Portal Reference: PP-10202800

Application: Application under Section 73 of the Town and Country Planning Act:
Proposed B1 offices and light industrial units and associated parking - Variation of Condition 2 (Approved Plans & Documents) of planning permission DC/18/03811 to allow alterations to the internal layout and appearance of Block H-L and Block D-G (originally approved under planning permission n 2638/15)

Site: Elm Farm Park, Great Green, Thurston, Bury St Edmunds Suffolk IP31 3SH

DRAWING NUMBER REVISION
4620-10 P8

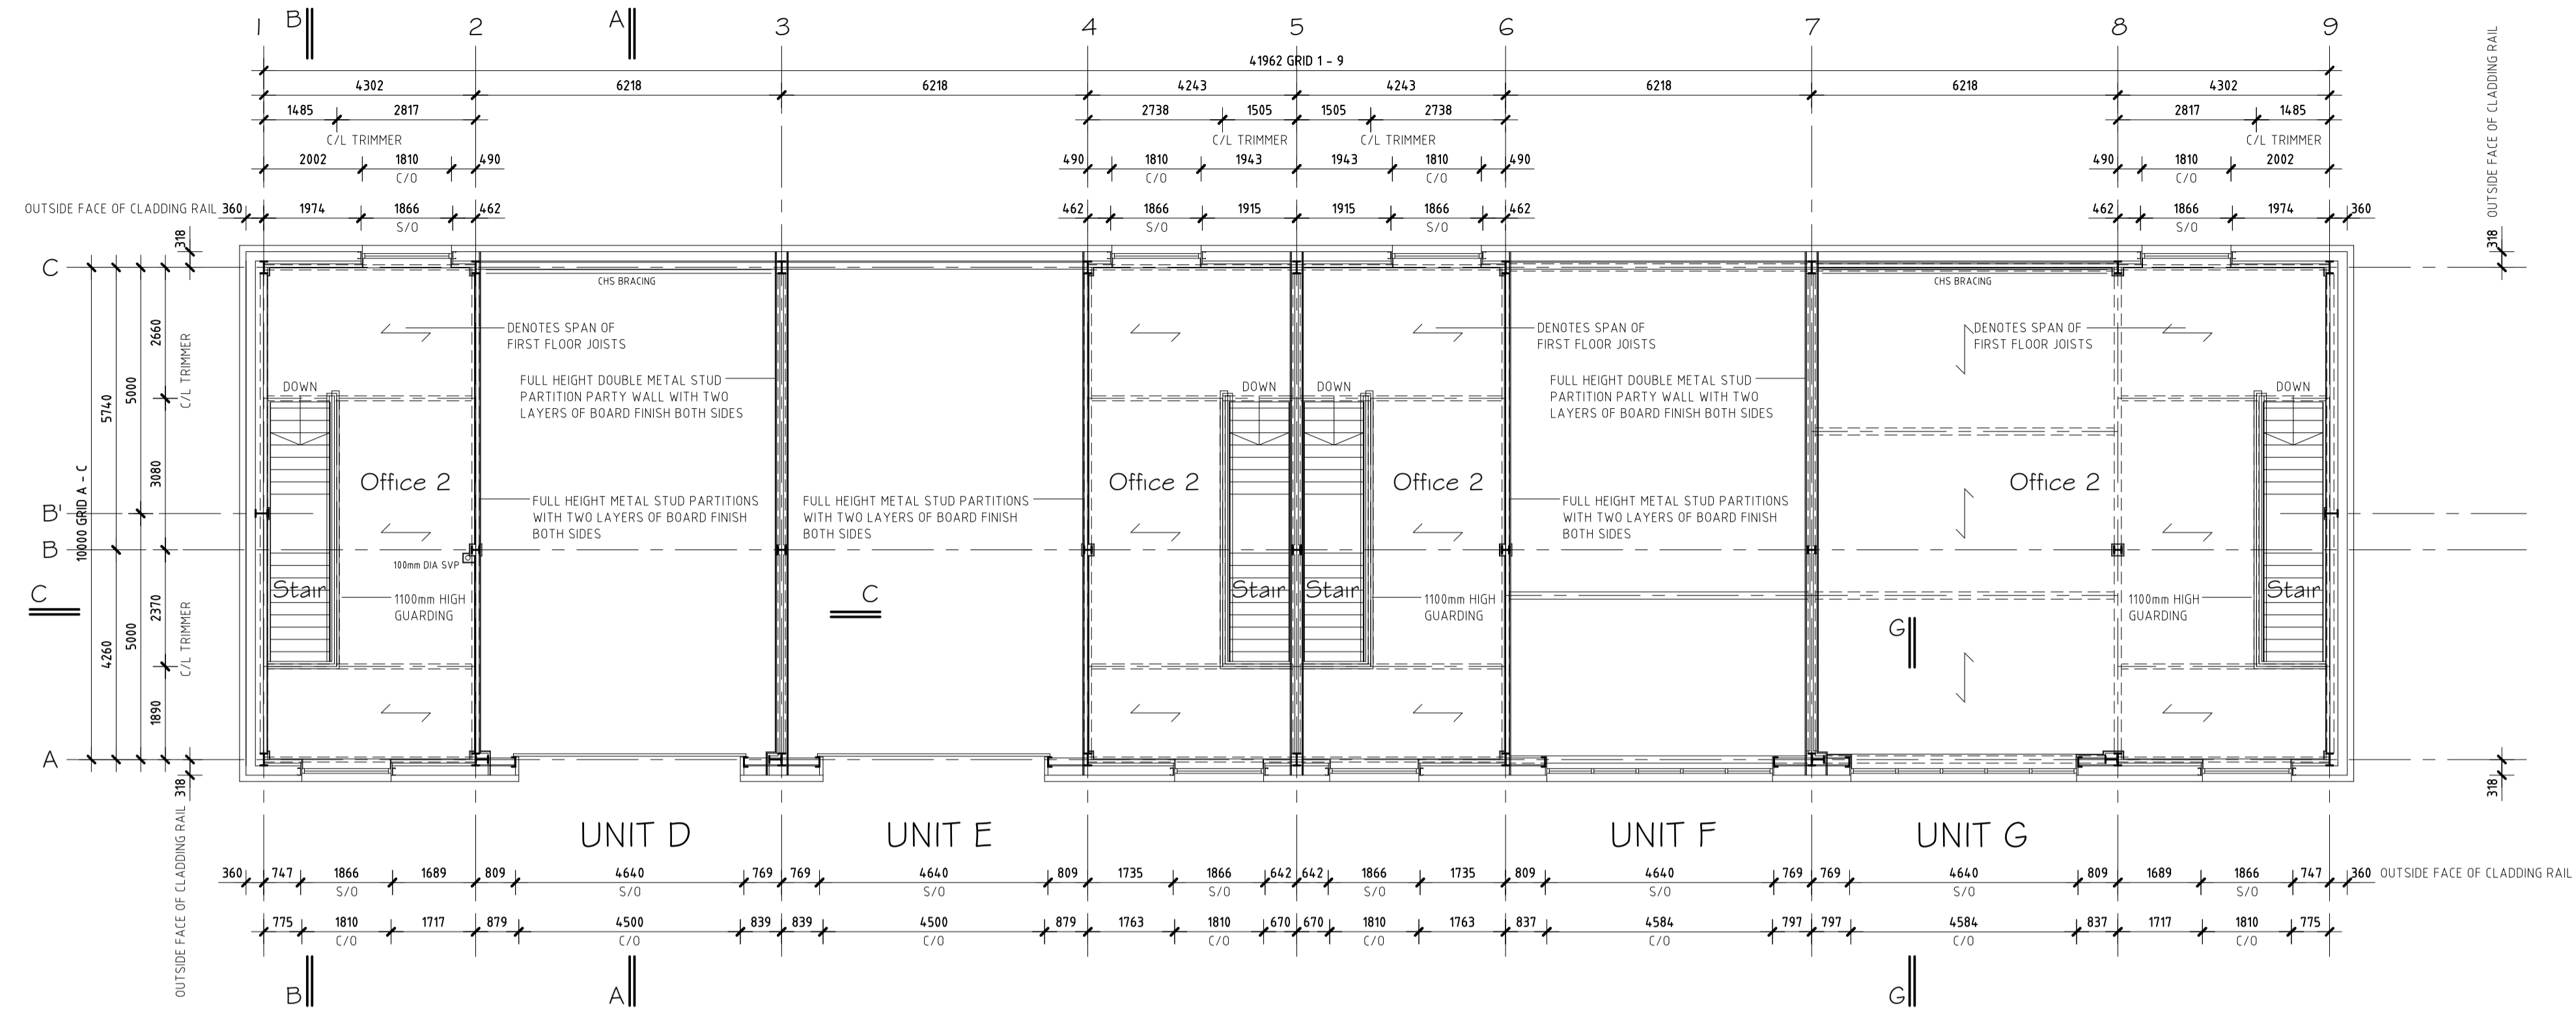
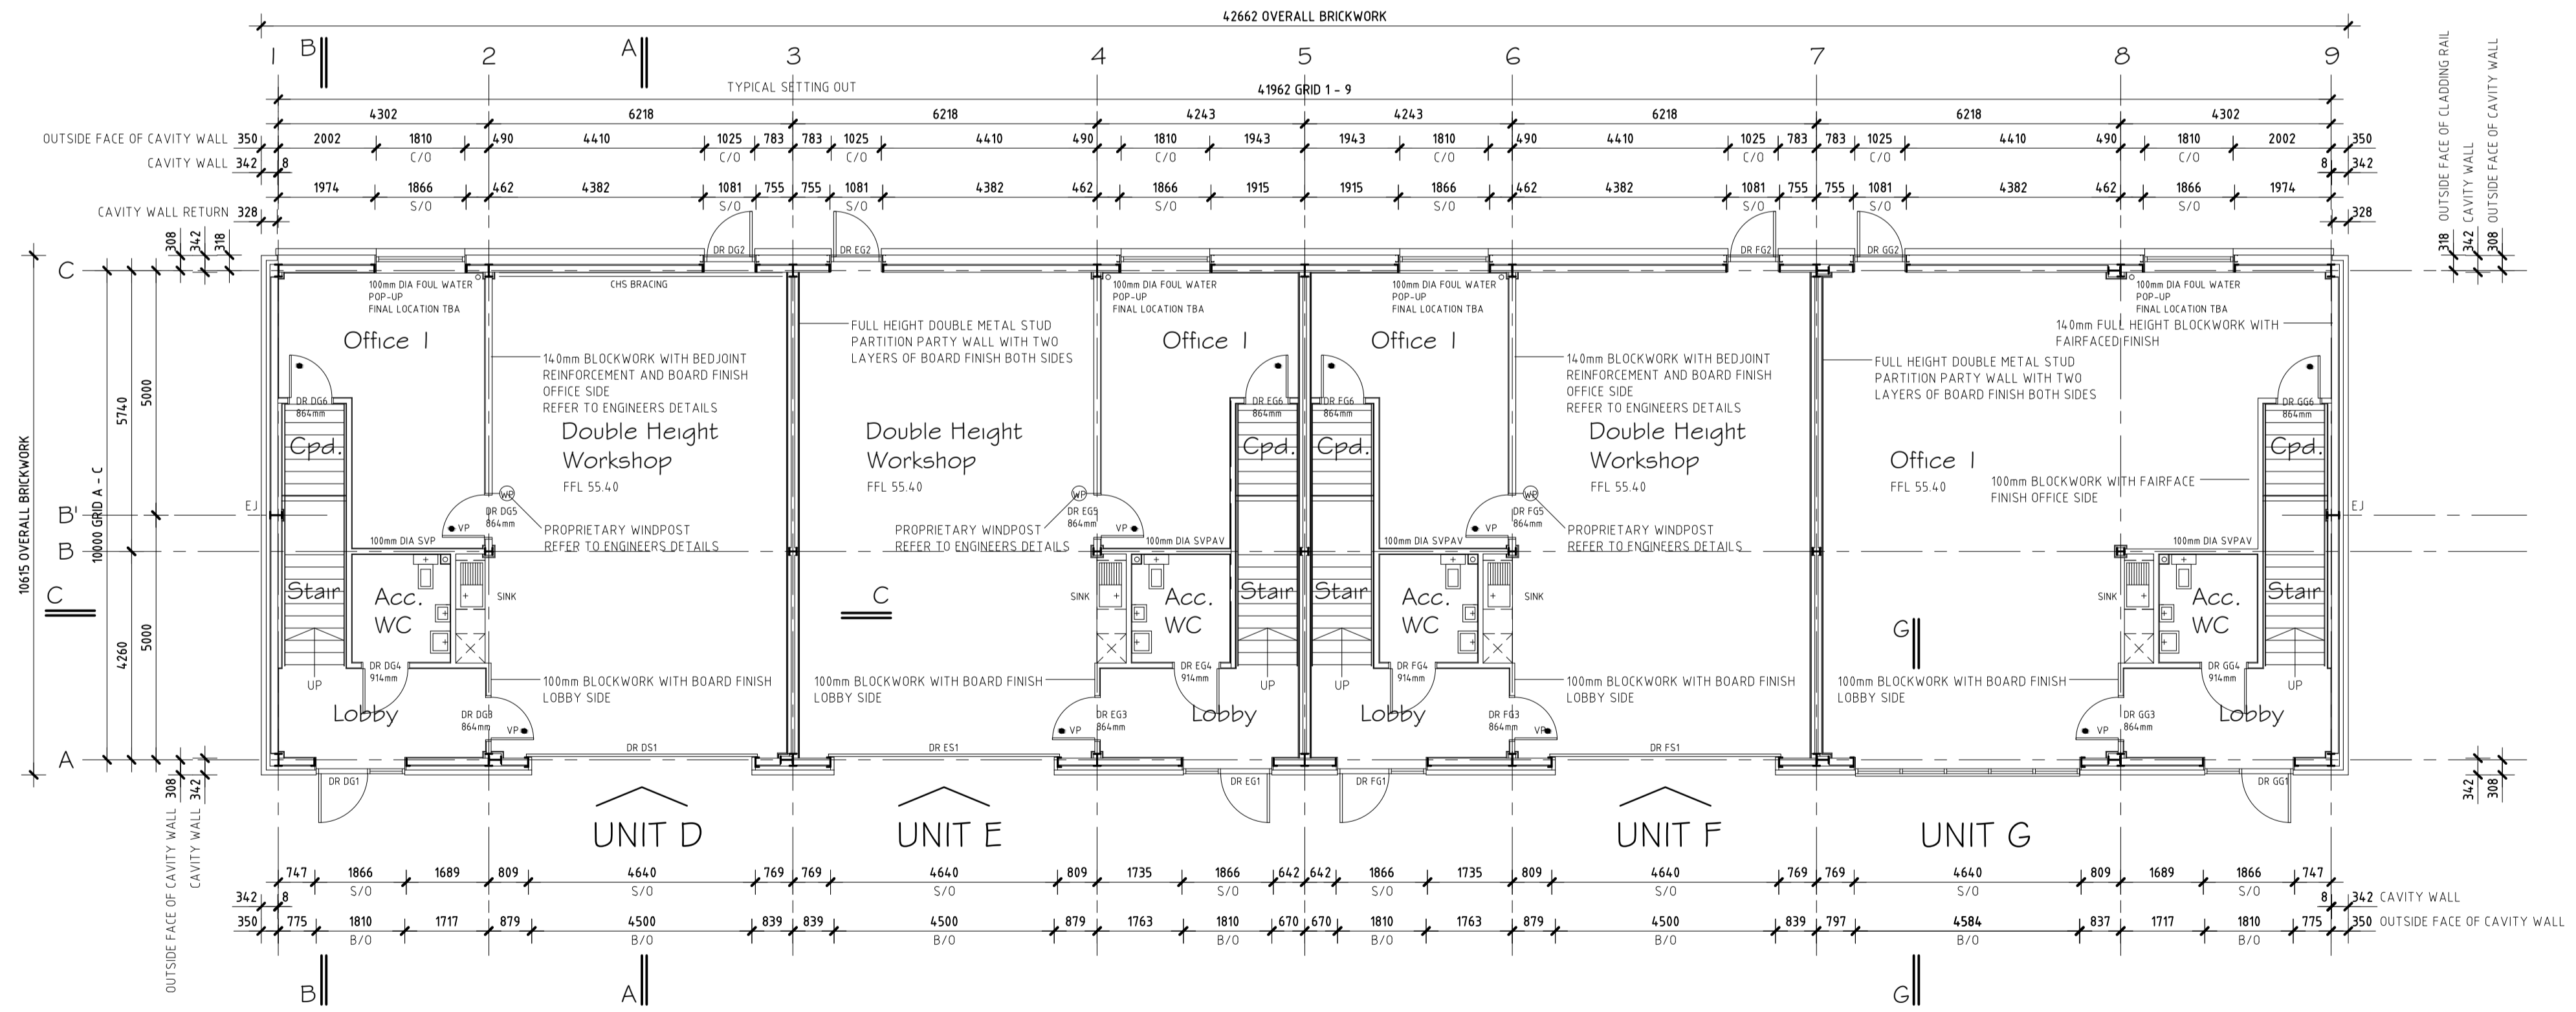
Plans and Elevations (A-C) Drawing number 02 Rev. A	/	No change
Plans and Elevations (D-G) Drawing number 03 Rev. A	Floor Plans Units D-G Drawing Number 4620-10 Rev P8 Elevations Units D-G Drawing Number 4620-11 Rev P3	Enlarged, accessible WCs Unit F – reduced height vehicle access door Unit G – vehicle access door changed to full height windows
Plans and Elevations (H-L) Drawing number 04 Rev. A	Floor Plans Units H-L Drawing Number 4620-20 Rev C9 Elevations Units H-L Drawing Number 4620-21 Rev C4	Position / layout of office accommodation amended Enlarged, accessible WCs Unit H – Installation of commercial kitchen and extraction Units H - L – vehicle access doors changed to full height windows or reduced in height and re-positioned to account for new internal layout
Tree Protection Plan & Landscape Proposal	/	No change
/	Unit H - Ventilation Details Drawing Number NWV8398/1	Additional plan showing extraction system and external flue details
